Report of the Head of Strategic Investment**STRATEGIC PLANNING COMMITTEE****Date: 30-Nov-2017**

Subject: Planning Application 2016/92298 Outline application for re-development of former waste water treatment works following demolition of existing structures to provide employment uses (use classes B1(c), B2 and B8) Former North Bierley Waste Water Treatment Works, Oakenshaw, BD12 7ET

Figure 12: Cliff Hollins Lane / Mill Carr Hill Road Mini-Roundabout Layout

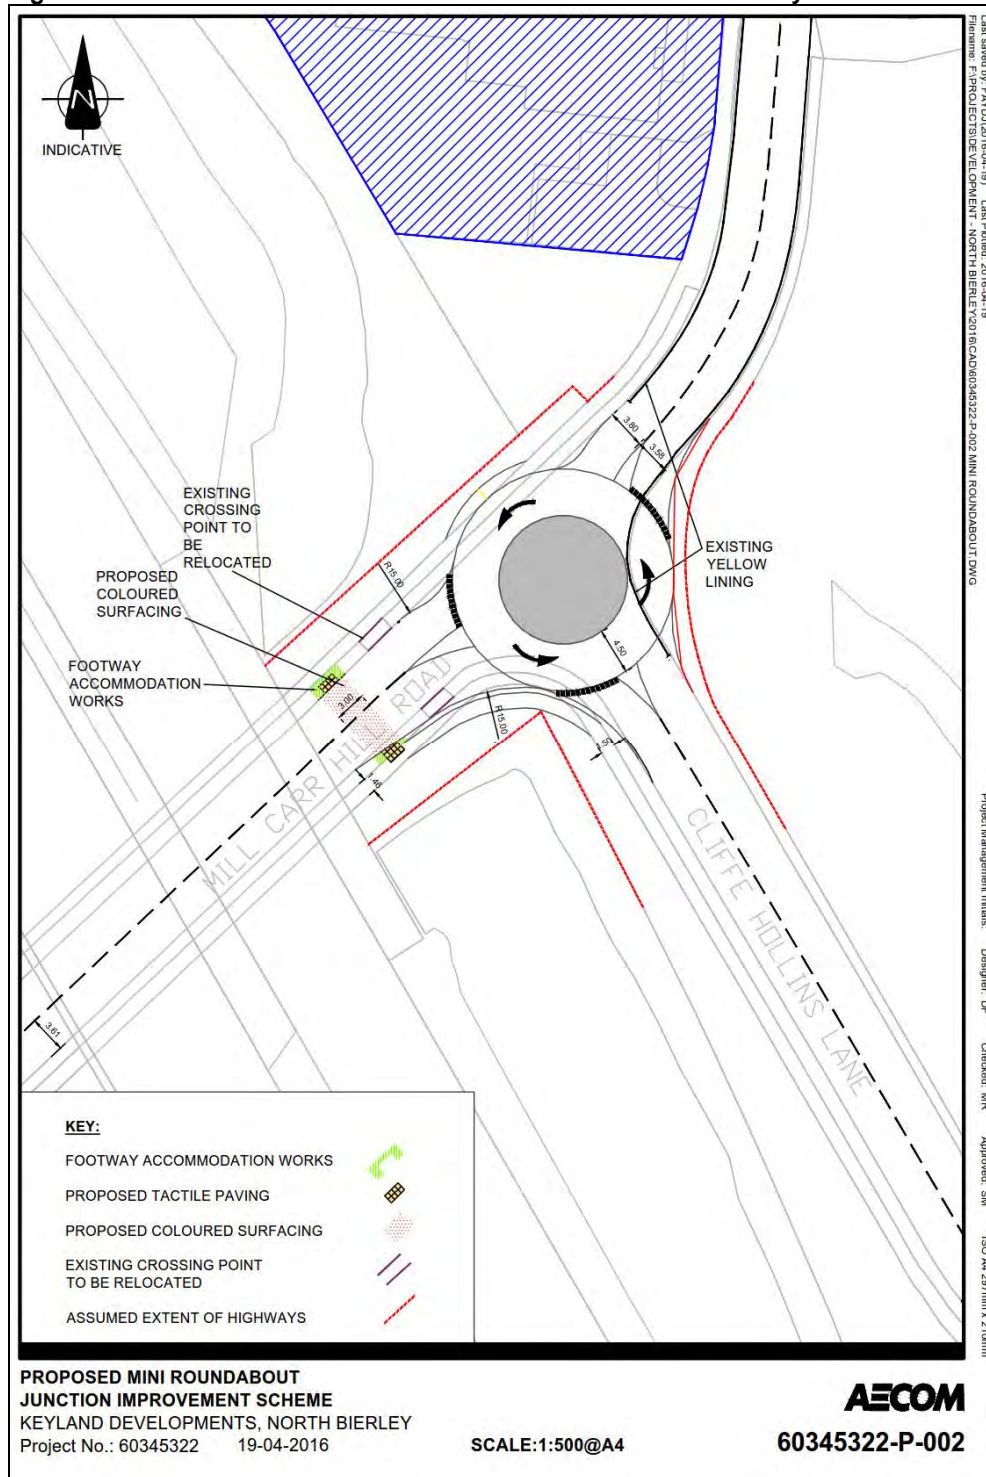
- Mini roundabout and T junction for Cliff Hollins Lane will not assist traffic flow in and out at this junction
- Bungalows on cliff Hollins will be boxed in

**Figure 13: Proposed Layout of Junction with Pedestrian Crossing**

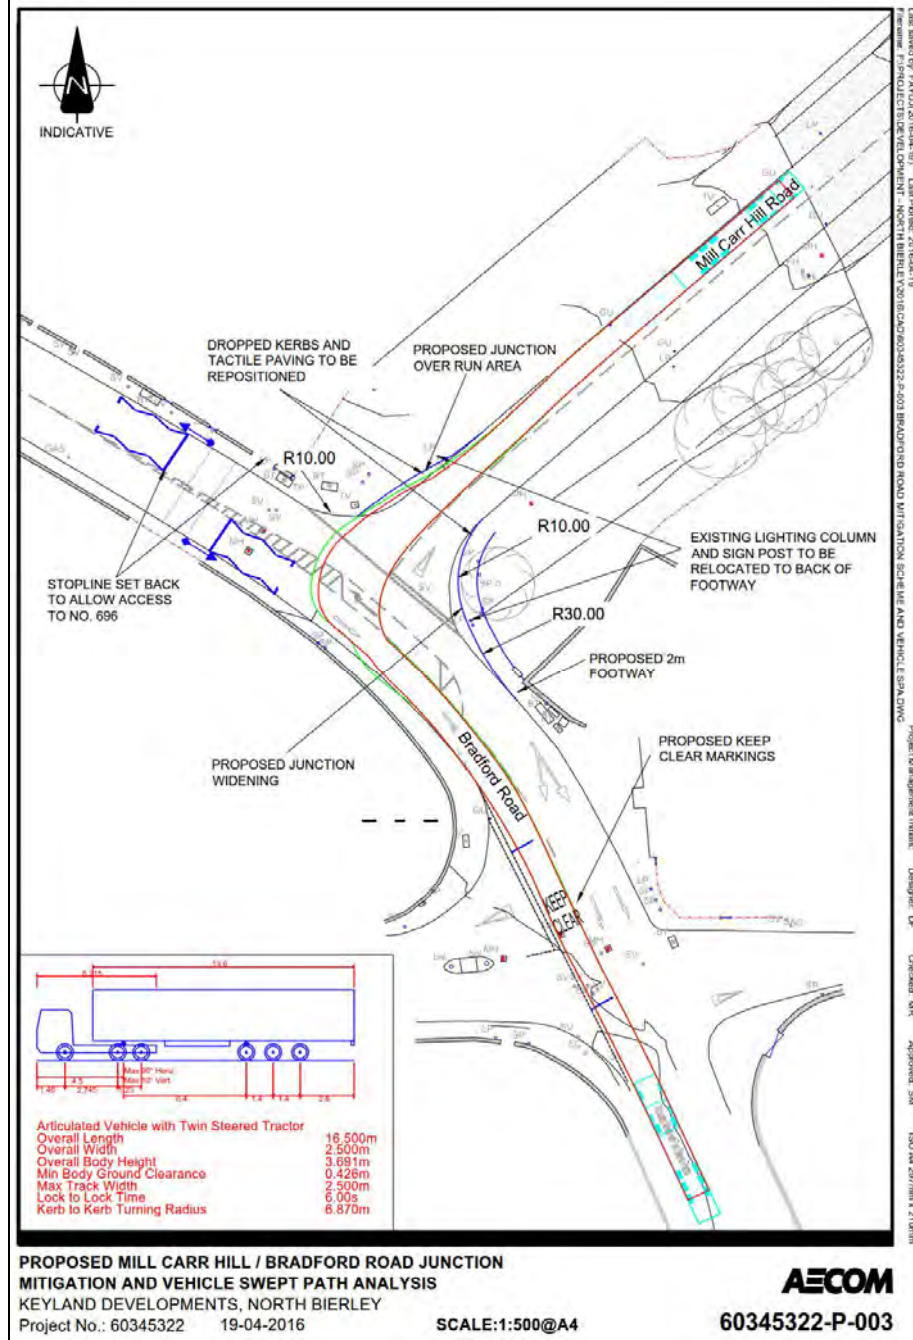
- Other sites discounted as not preferable sites
- The need is questioned
- The addition of a pedestrian crossing will reduce safety concerns but will exacerbate existing highway safety and traffic flow issues

**Figure 14: Proposed Car Park**

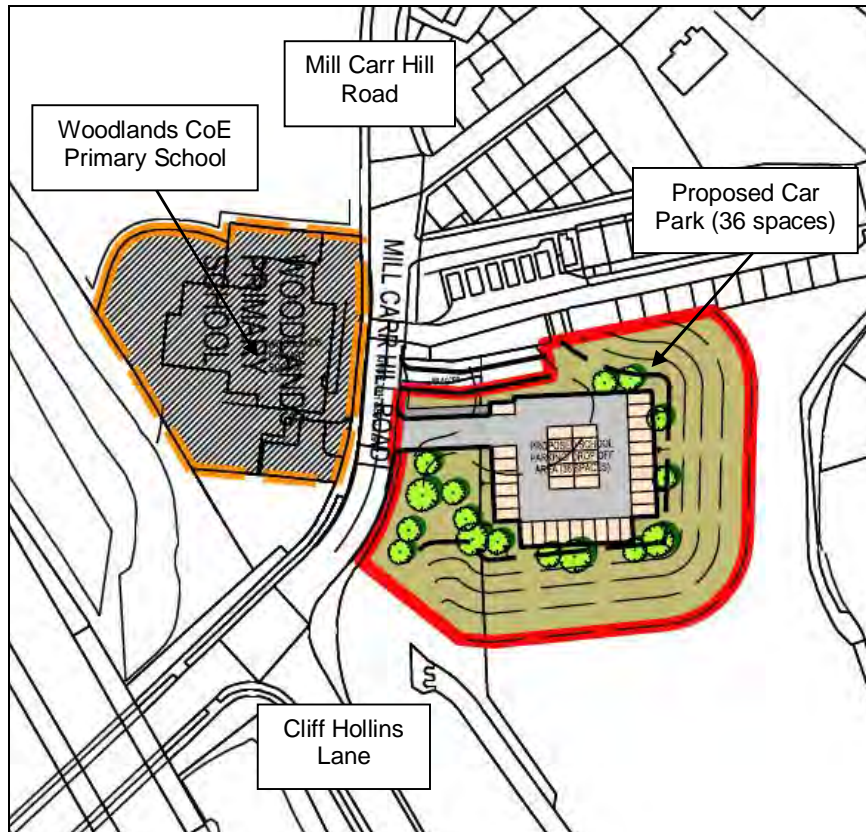
- The increase in traffic and footfall will endanger children's lives, it is too close to the entrance of the Primary School (adjacent to their playground) exposing them to toxic fumes, the addition of an extra car park and drop off point will encourage more cars to use the area.

A 36 space car park has been submitted to the neighbouring authority (Bradford) in order to alleviate existing on-street parking pressure occurring on Mill Carr Hill Road associated with Woodlands Church of England Primary School.

STATUS	■ PLANNING	SCALE	■ 1:2500 @ A1	AS	
FILE	■ P:\PROJECTS\			DATE	■ APR 16
PROJECT	■ 1773-01	DRAWING	■ 207	REVISION	■ H

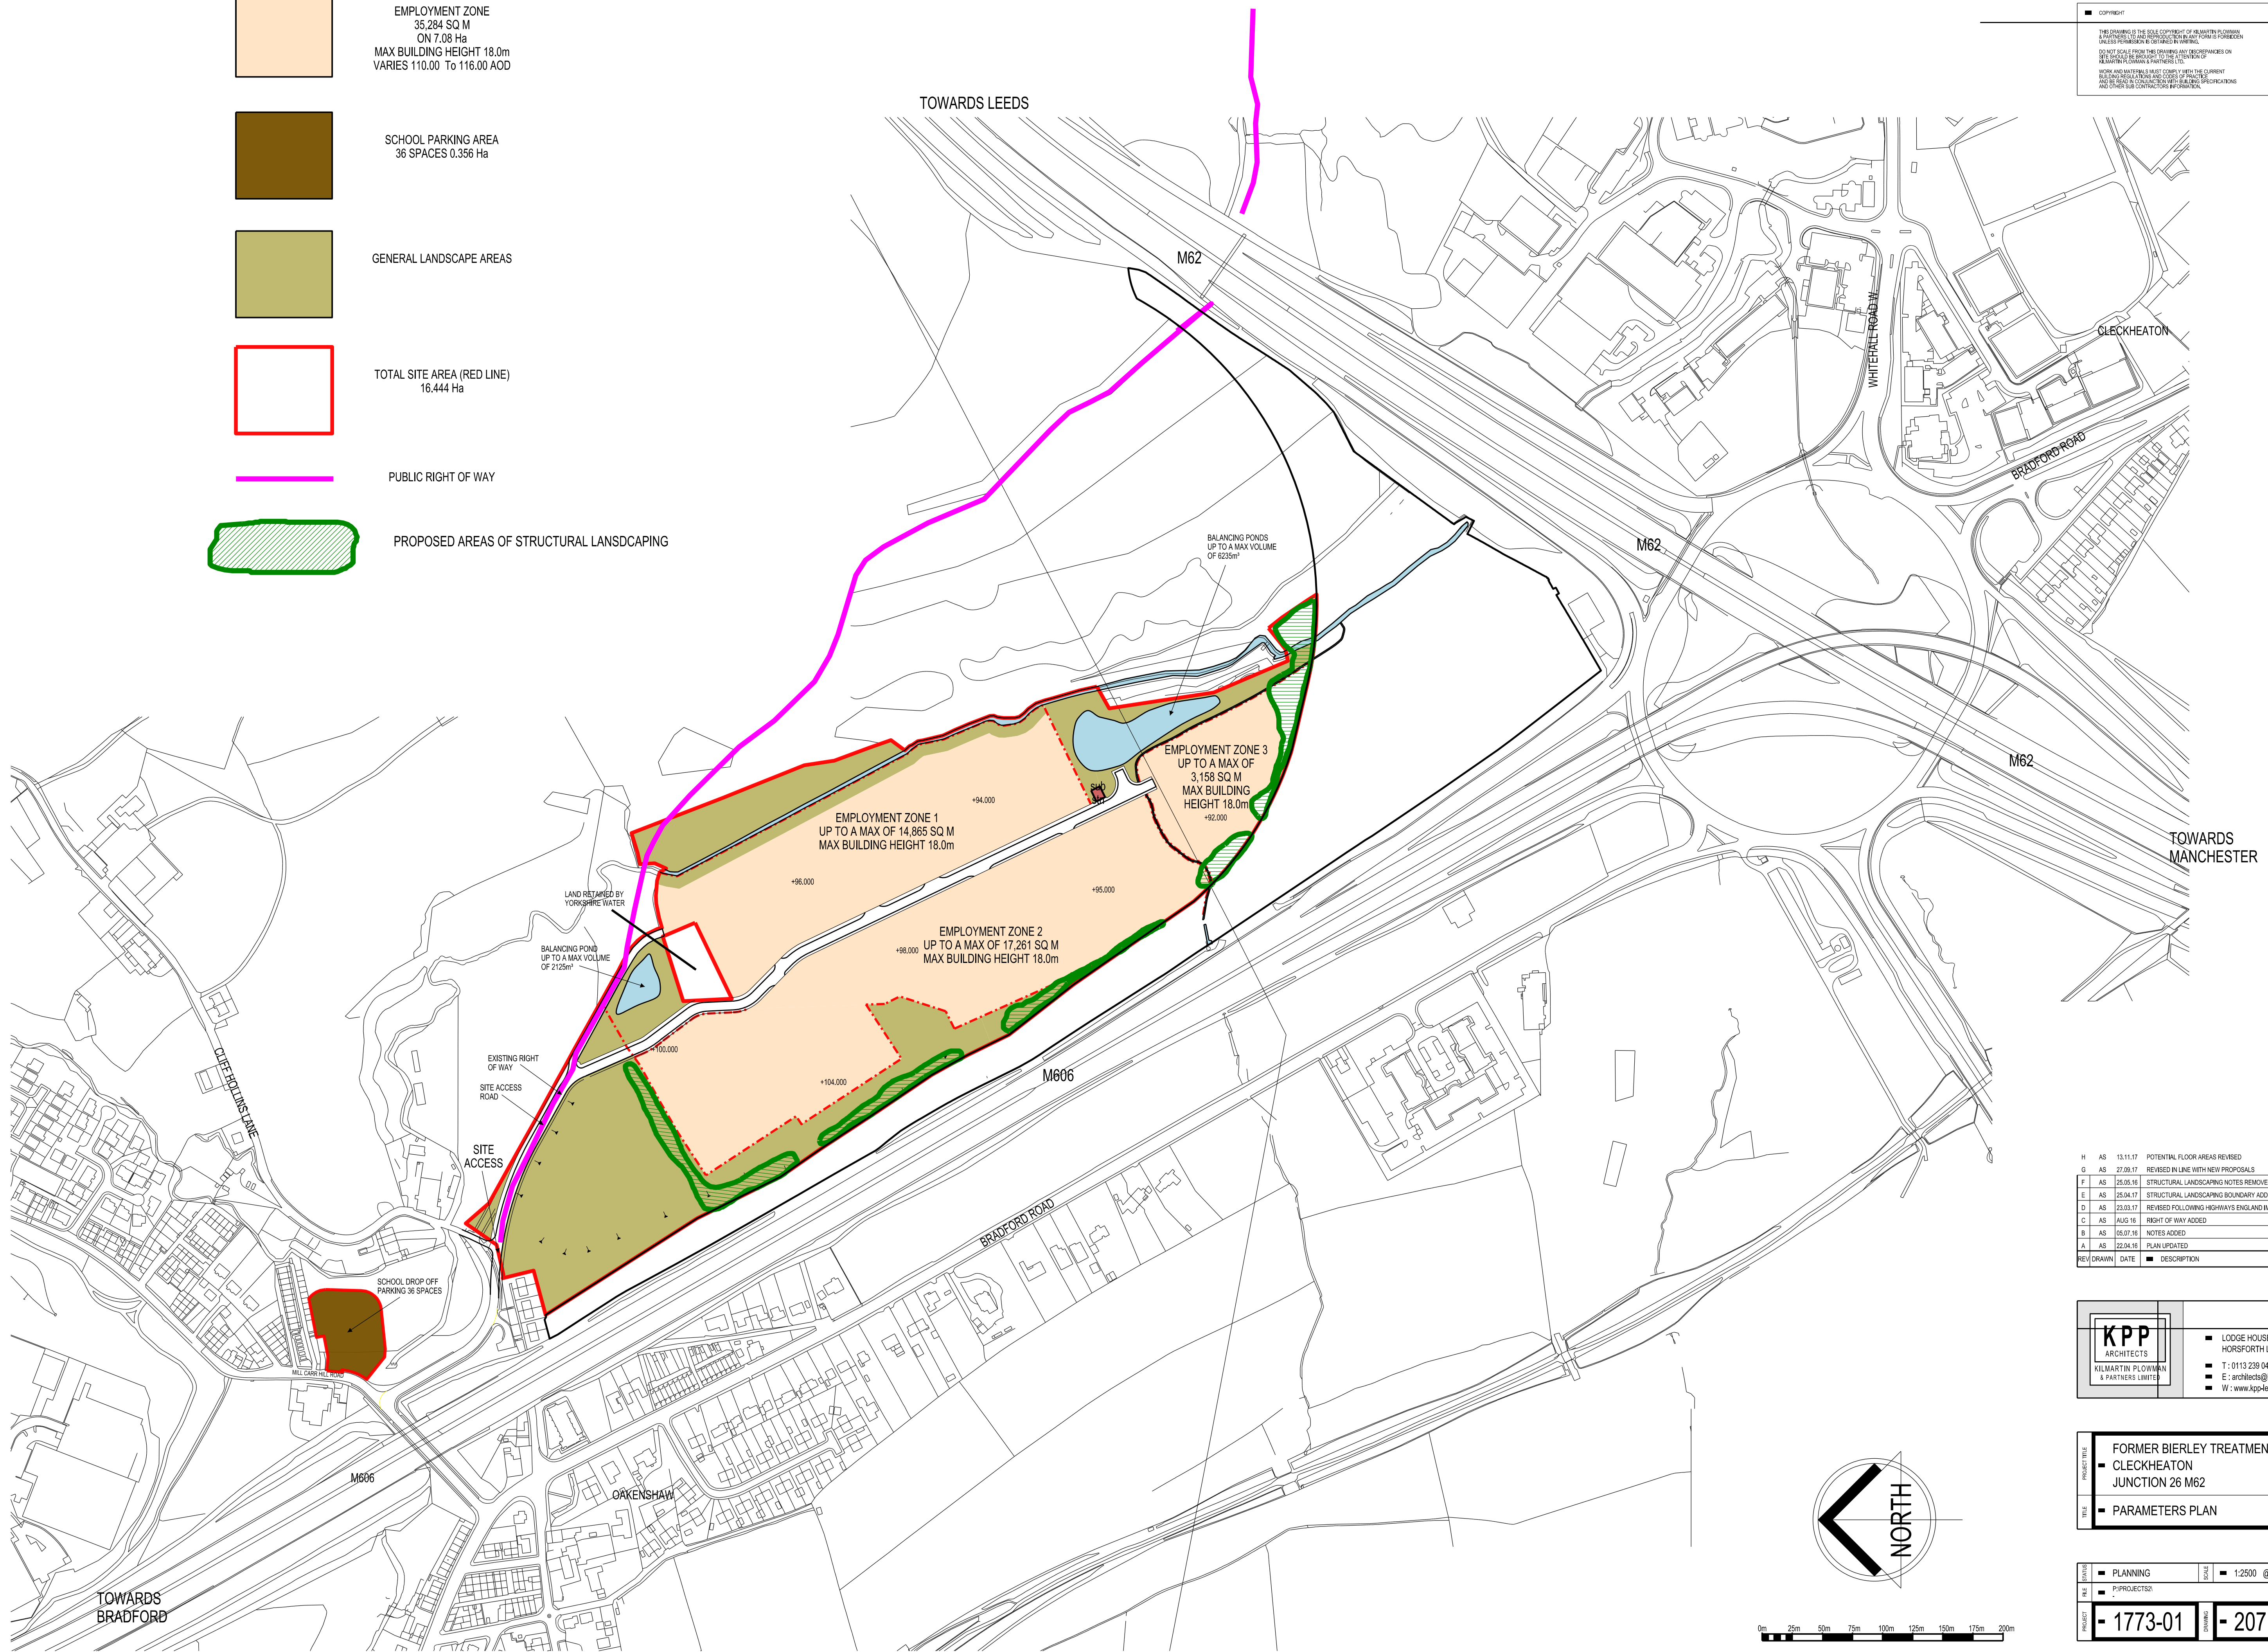
- 10.38 The application documents include an indicative site block plan which demonstrates how the site could be developed. Whilst, this layout is acceptable in principle, consideration would need to be given on any subsequent application to the scale, design and materials to ensure the proposed buildings do not significantly detract from the openness of the greenbelt to accord with Kirklees Unitary development plan Policies BE1 and
